Application No: CM/38/21/PL
Site Address: The Arundel Gardener and Maidenhead Aquatics Crookthorn Lane Climpling BN17 5SN
Description of works: Retention of timber cladding to side (west) & rear (south) of main building, Laying new shingle to existing made ground, lychgate to west of main building, timber cladding to generator housing & laying block paving and concrete slabs/replacement concrete slabs. This site may affect a listed building & is in CIL Zone 5 (Zero Rated) as other development.

Thank you for your internet representation made on 9th August 2021 which has been recorded as an objection with the comments as follows:

*As-Existing Site Plan
with Proposals*

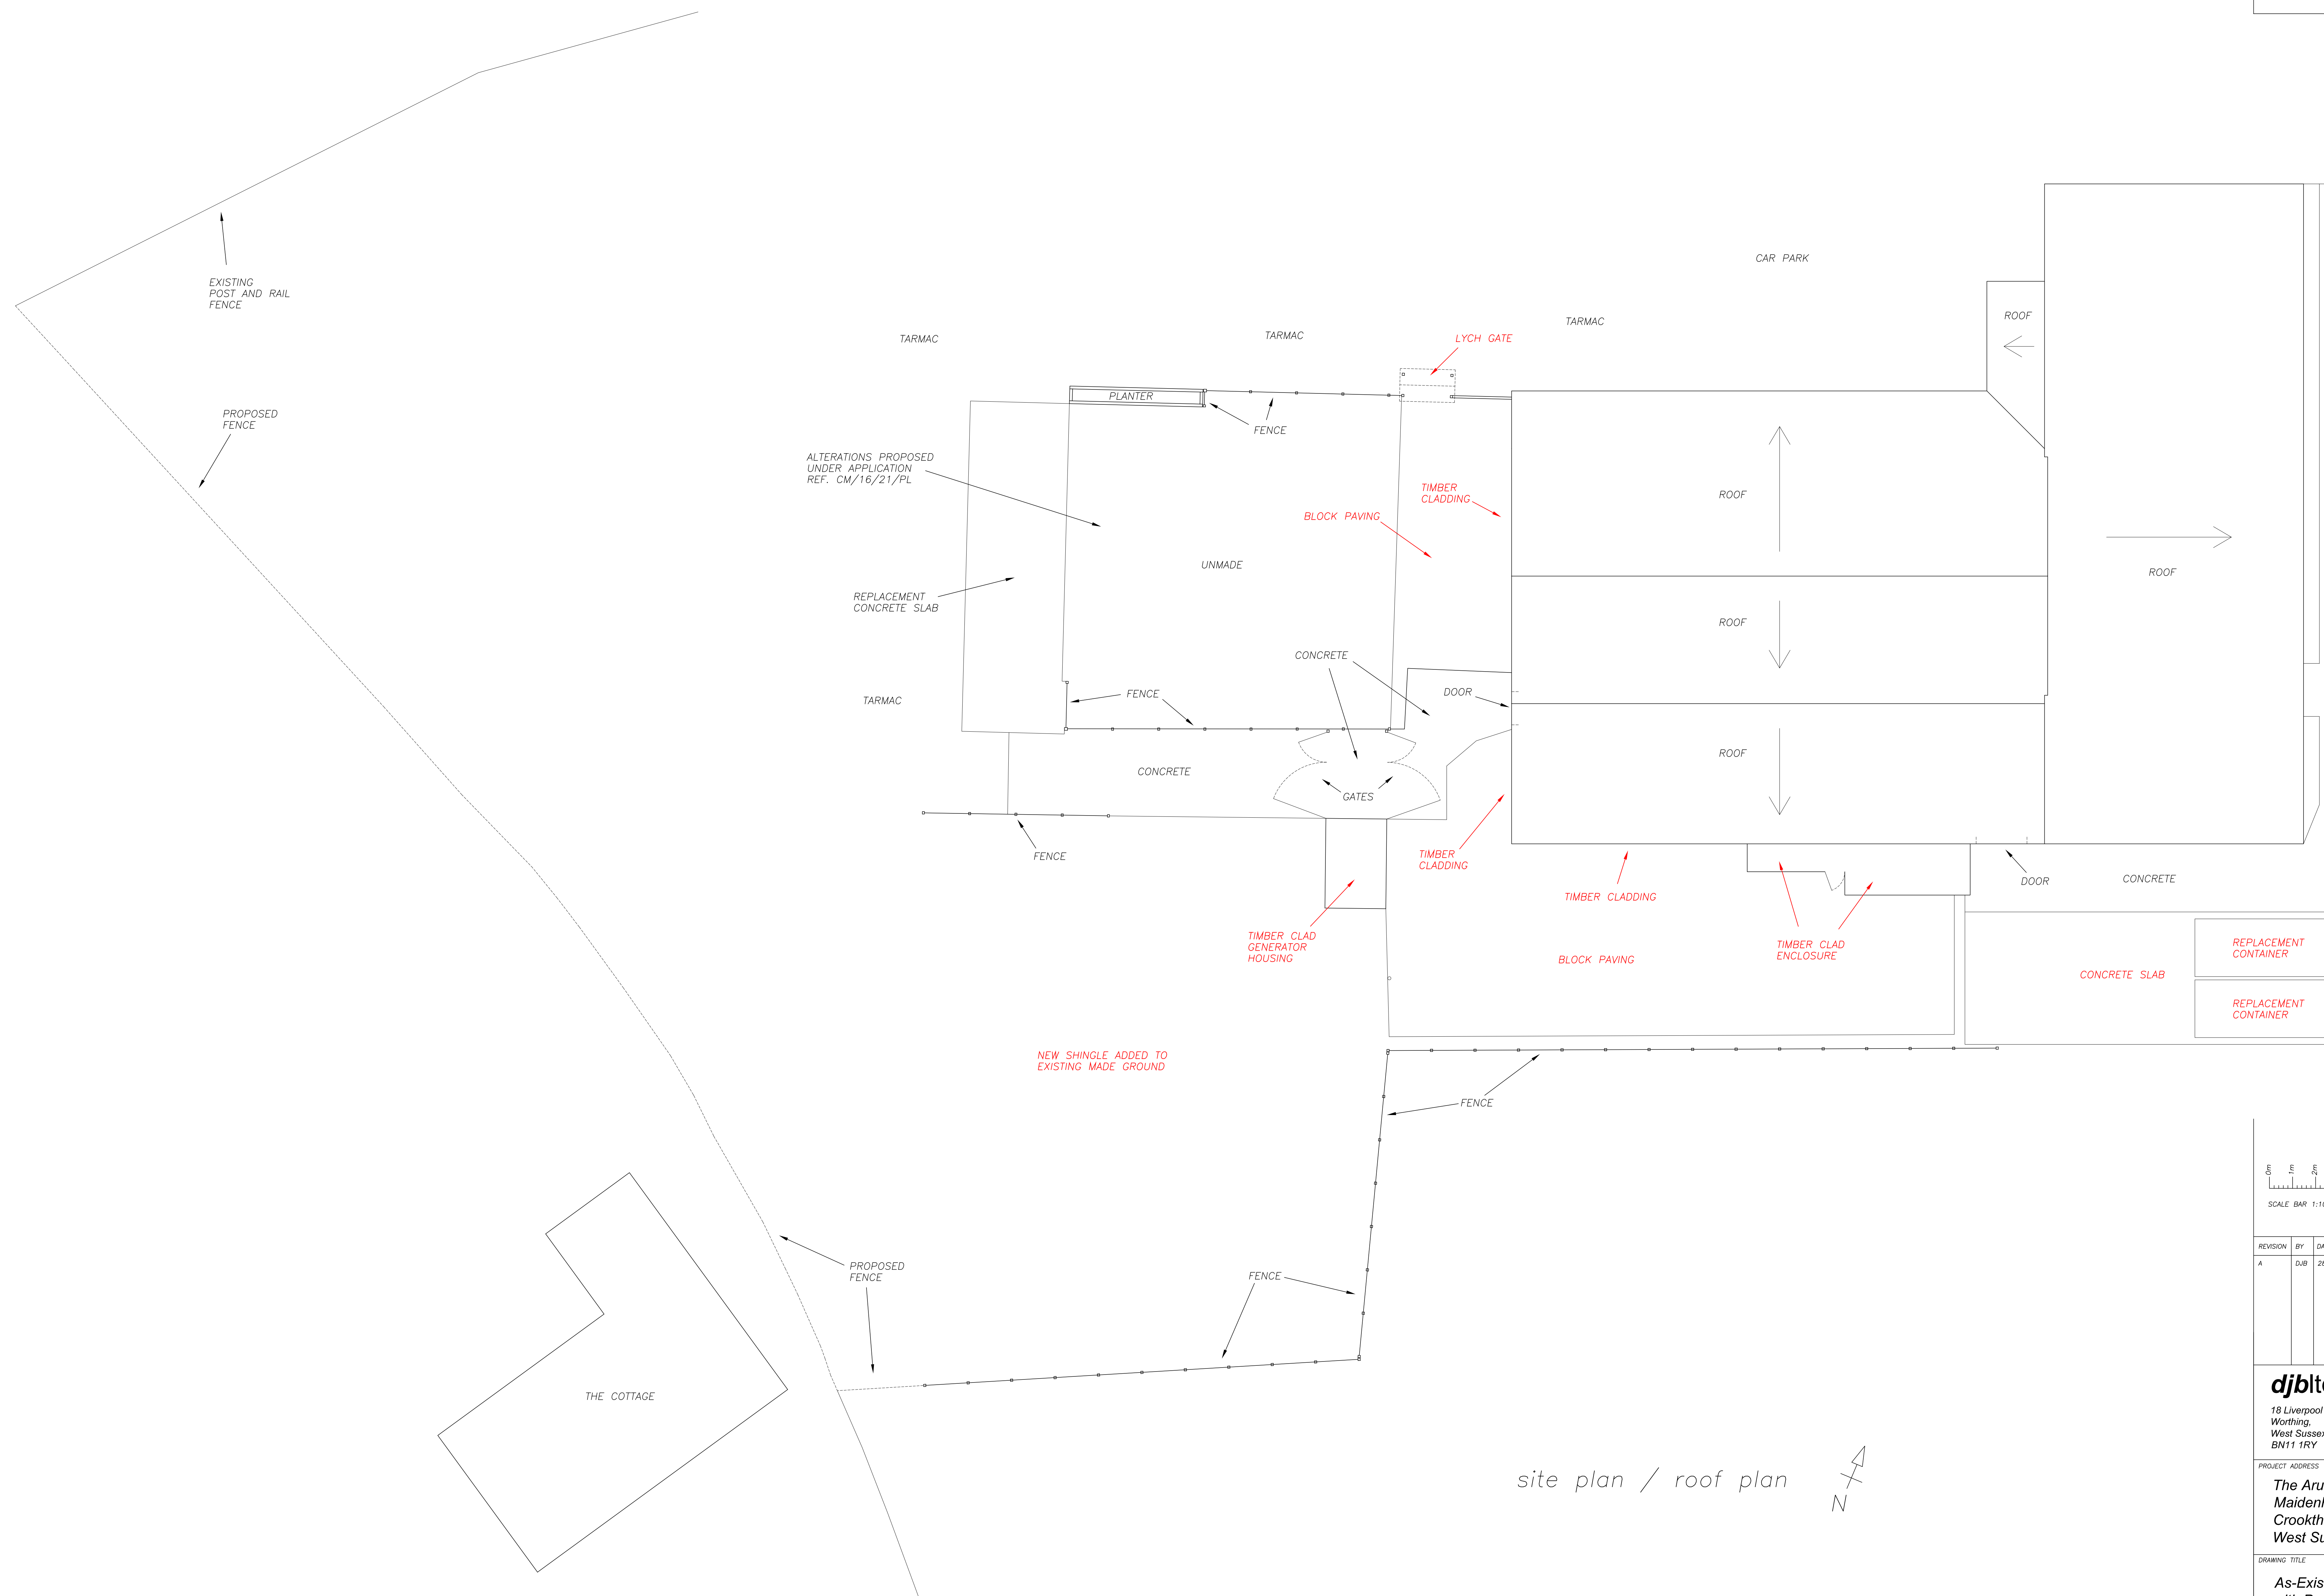
Clympling Parish Council Objects to this application and asks that the planning officer informs the parish council of the reasons and intended use of the area of new shingle laid on previously natural open ground
